# PORTLAND MAINE

September 13, 2012

**RE: 433 Fore Street – Canal Plaza Hotel**  
**Level III Site Plan Review**  
**Application ID Number: 2012-558**

UTILITY PLAN

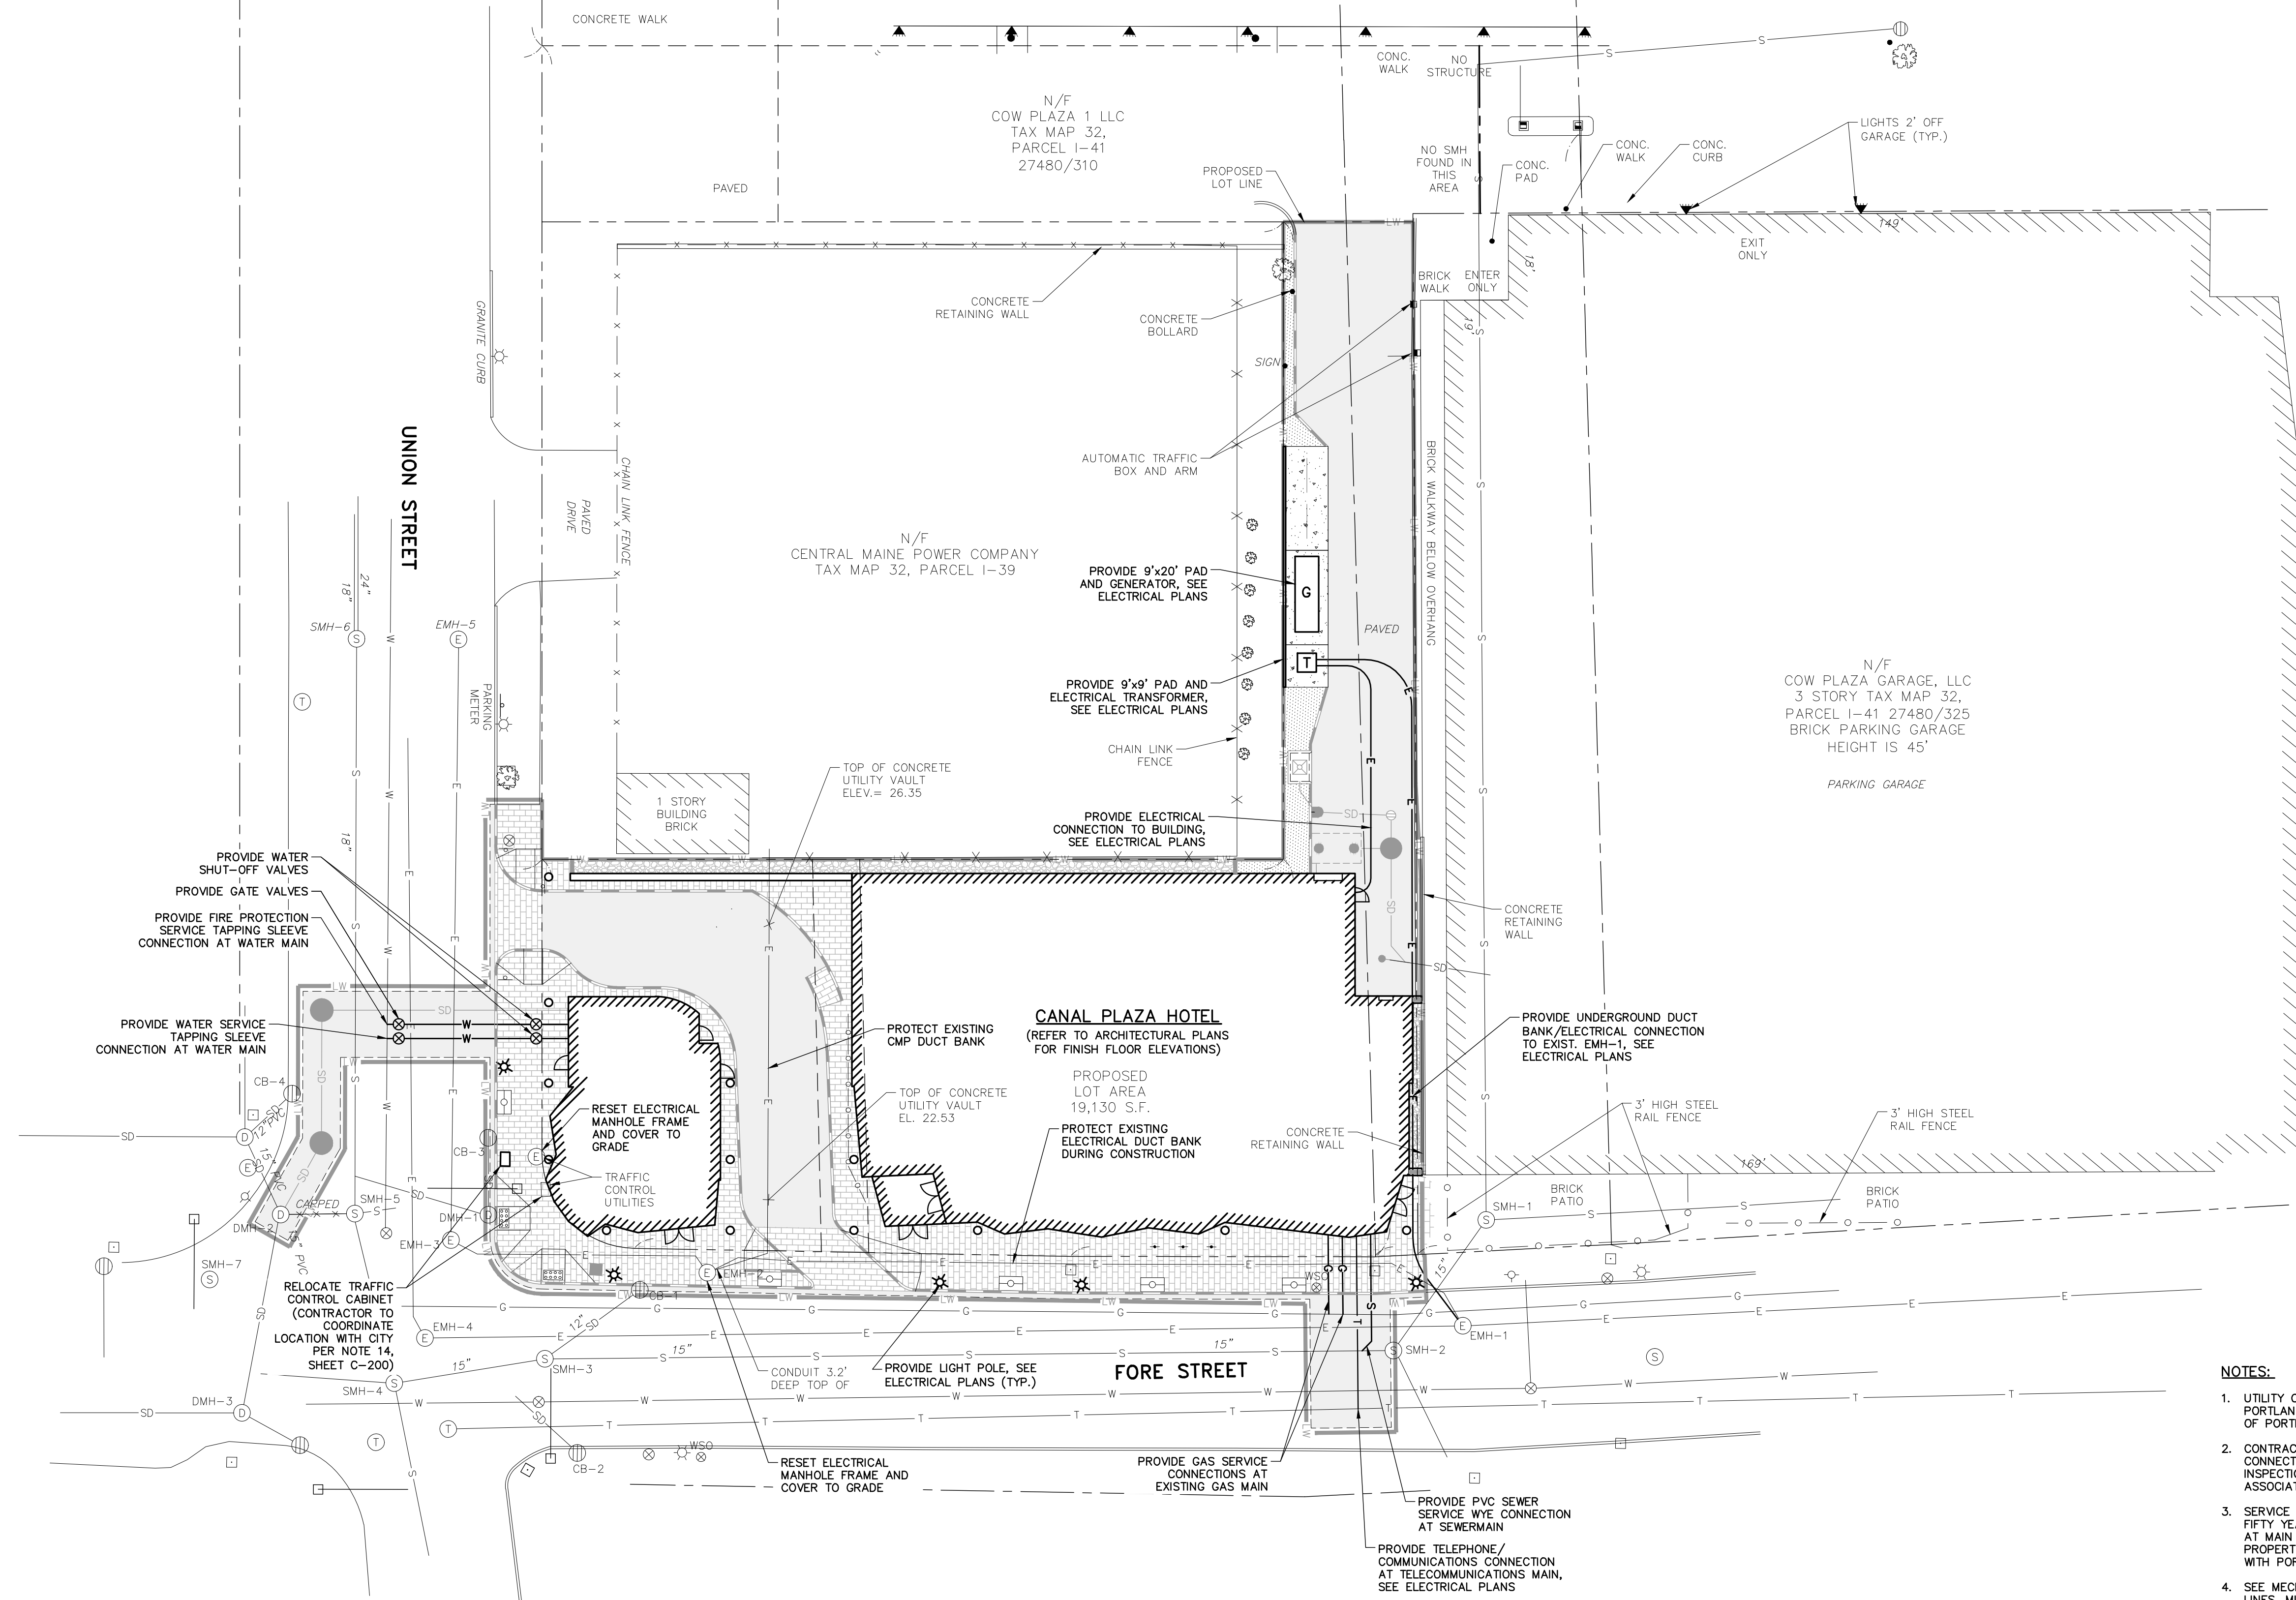
The plan appears to indicate a transformer pad to the north side of the building within a 6' wide landscaped area. Typically pad mount transformers are no less than 7'x7' in dimension up to 9'x9' in dimension, so the engineer should review. The engineer should confirm CMP setback requirements for the transformer pad. Will an emergency generator be necessary, and if so, where will it be located?

The applicant's engineer should review pipe systems in Union Street with respect to storm drainage and water and conflicts with existing utilities running up and down Union Street. Profiles and/or test pits might be beneficial.

Has CMP reviewed, and have they accepted, the location of the underground primary power supply along the easterly side of the building? If so they should be shown on the plans.

It is unclear if the utilities are to be shared between the two buildings [i.e. retail and hotel]. If so, will these utility lines go underground beneath the entrance driveway?

We note the lowering of ground grades above the existing CMP duct bank and wonder if test pits are necessary to confirm depth of that existing piece of infrastructure and will the lowering of grade over it negatively impact it.

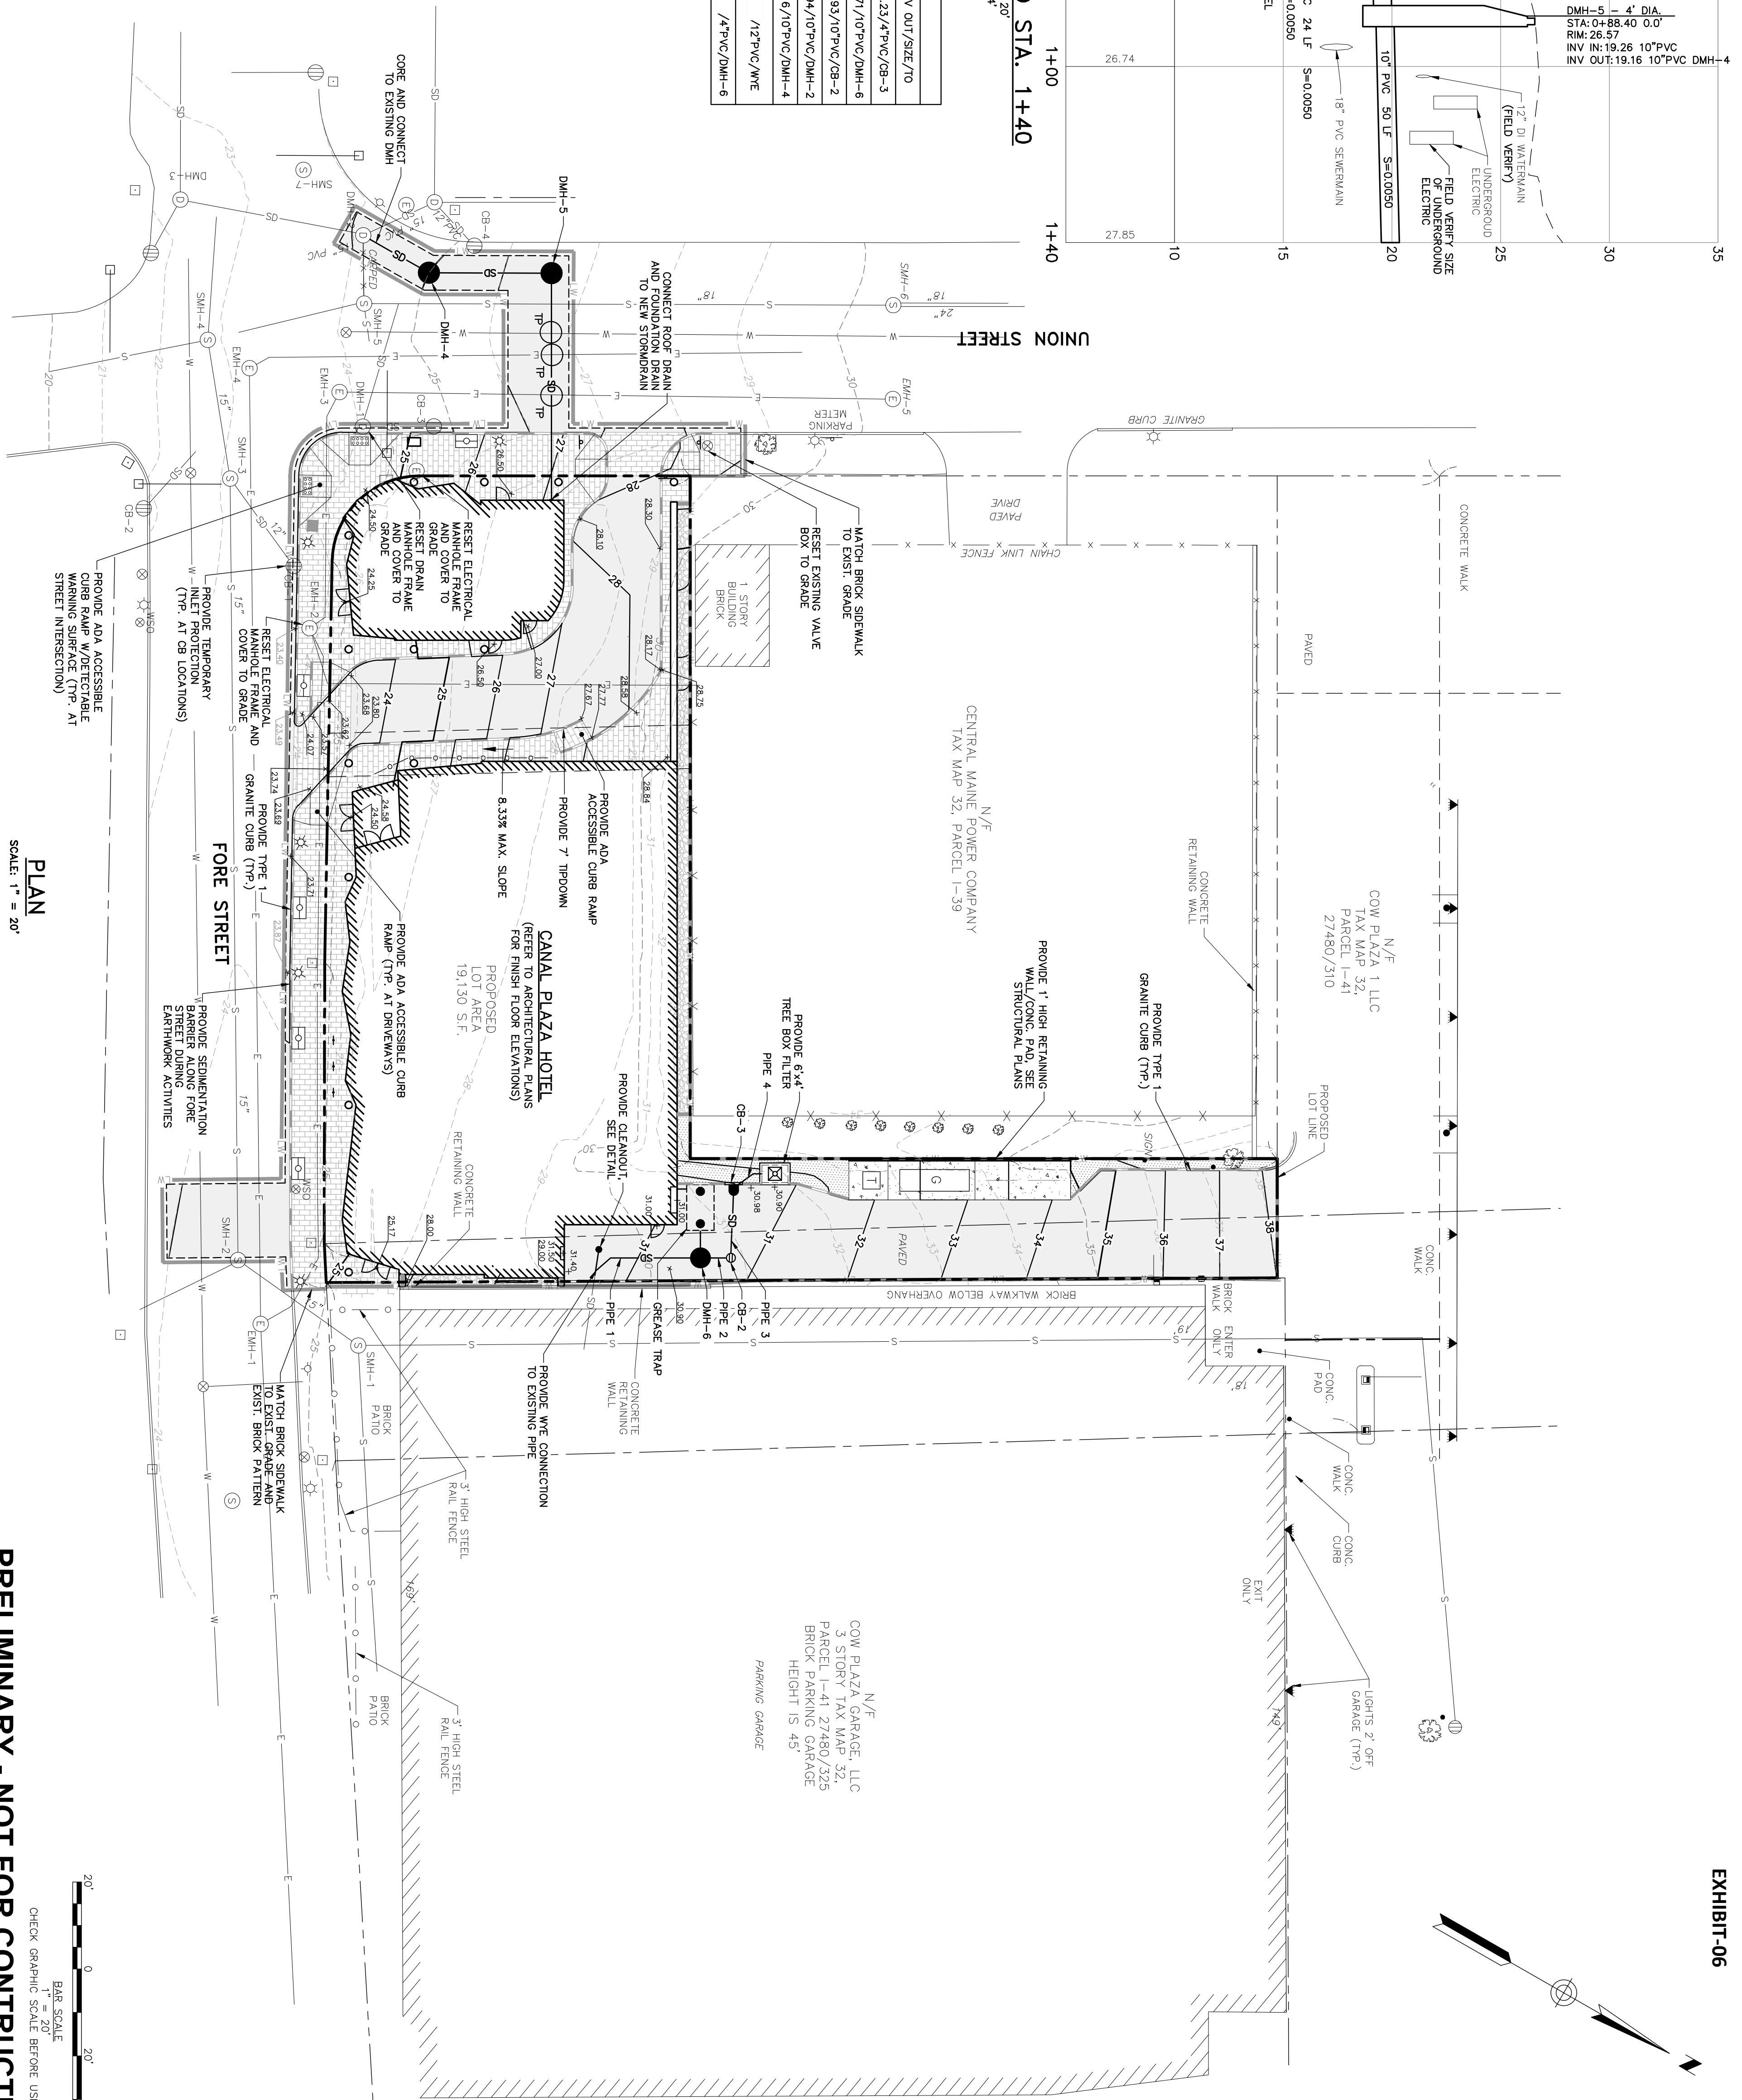
Details pertaining to the tree box filter should be provided, including sizing, plant material, piping, etc.

Roof drainage should be clearly identified and discussed as to connection points, etc.

Design info for all proposed storm drainage and appurtenant structures will need to be indicated on the next round of drawings.

Spot grades at entrance locations and along the sidewalks would be beneficial and are recommended.
